Deadline 8 follow up submission

Dear Sir/Madam , I am writing with regards to my earlier Deadline 7 submission and following up from that . It summarised that

Figure 11A.3 - Sharps Redmore rail sound survey locations

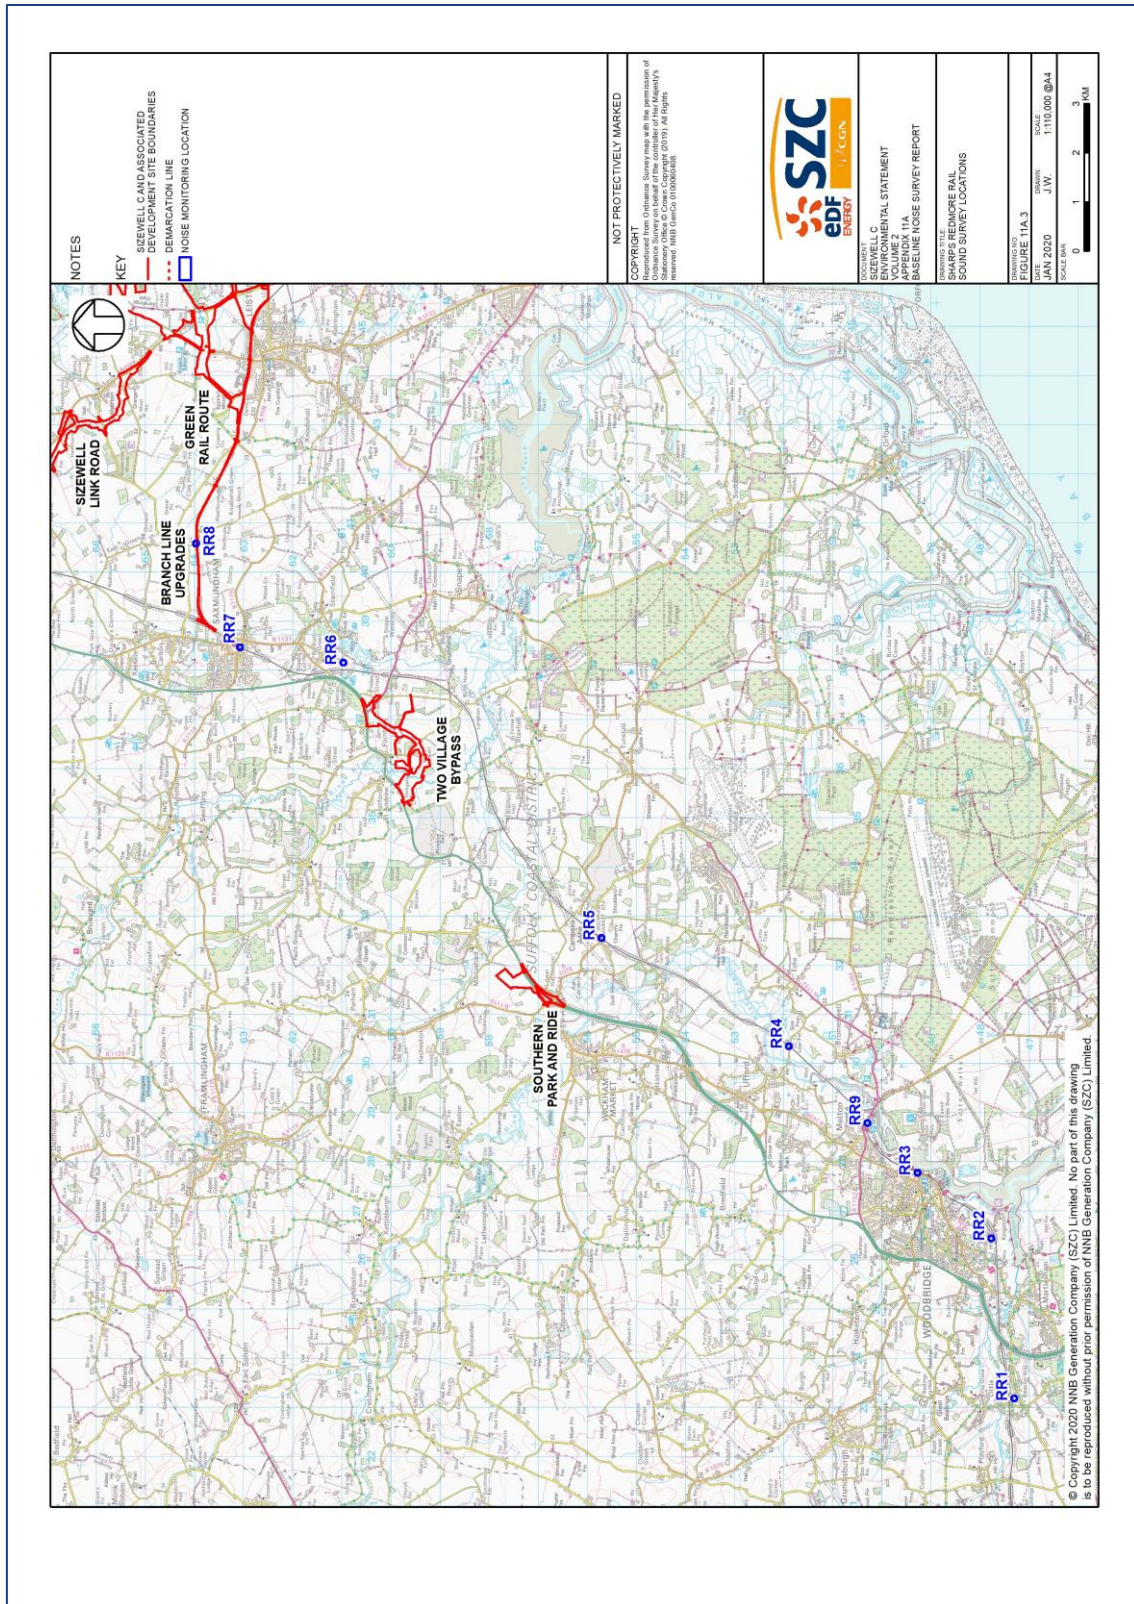
Going back to the first point with regard to the Monitoring stations firstly these Baseline data collecting locations should primarily follow the route from where later, the construction and then operational phases are , then expand out to additional remote locations of importance (receptors) to form satellite studies starting with those nearest the route. Quoting the methodology "Baseline sound level surveys have been undertaken for the most part at locations representative of residential receptors in the study area " so MS39 should have been at the rear of Aldhurst farm cottages and MS40 at the rear of Fishers Farm both locations closer to the proposed route and arguably much more accurate indicative readings would have been taken.

MS39 while suitable for a secondary location is not suitable for a primary one its proximity to both Abbey lane and Abbey road both of which are at a point when engine noise increases Abbey road where traffic exits Leistons 30mph limit and entering Abbey lane also exiting a 30mph zone additionally there is an incline travelling west at the start of the lane past MS12 increasing engine noise further. MS40 is also only suitable as a secondary location not as a primary one . It is furthest away from the GRR with Abbey lane running adjacent to it . The readings also were taken at its busiest time in peak season when the Park is at capacity and coinciding with the Harvest in the surrounding fields. The worst time to collect data to have any accurate meaning . Both graphs clearly show the biasing of the road traffic noise at peak times in both the morning and evening . Also to note for this section of the GRR three other MS locations all further away from the GRR MS12 MS18 and MS38.

## MS39 – Leiston Abbey residential block

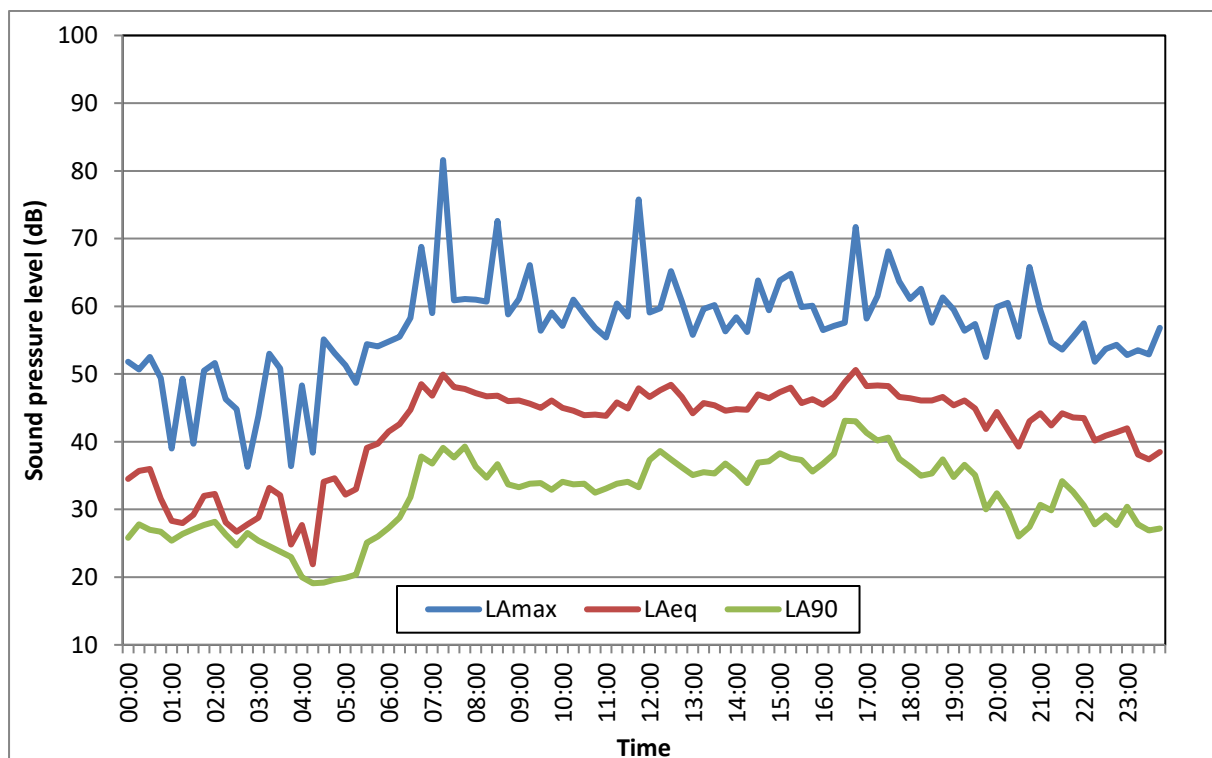
However all it seemed to achieve was a widening in our opposing stances and galvanised my view that both the methodology and results of their modelling were inaccurate and flawed. The two main points discussed were that that the two Monitoring Stations (MS40 & MS39)used to form a baseline level for the Green Rail Route (GRR) west of Abbey road were in the wrong positions giving false misleading data and that the noise contours produced for later years night-time Rail extension section showed anomalies which Mr Brownstone was unable to give a credible explanation to . We discussed also the use of the Nord 2000 module in SoundplanTM which I am of the view which will better show the devastatingly negative impact of noise to those along the GRR. Mr Brownstone agreed he would provide this as soon as he was able to , a relatively simple task by running the already inputted data along with wind speed and direction into the Nord 2000 module of SoundPlanTM. As of today's date nothing has been forthcoming from Mr Brownstone . I would ask the Inspectorate to see if they are able to request this from the applicant .
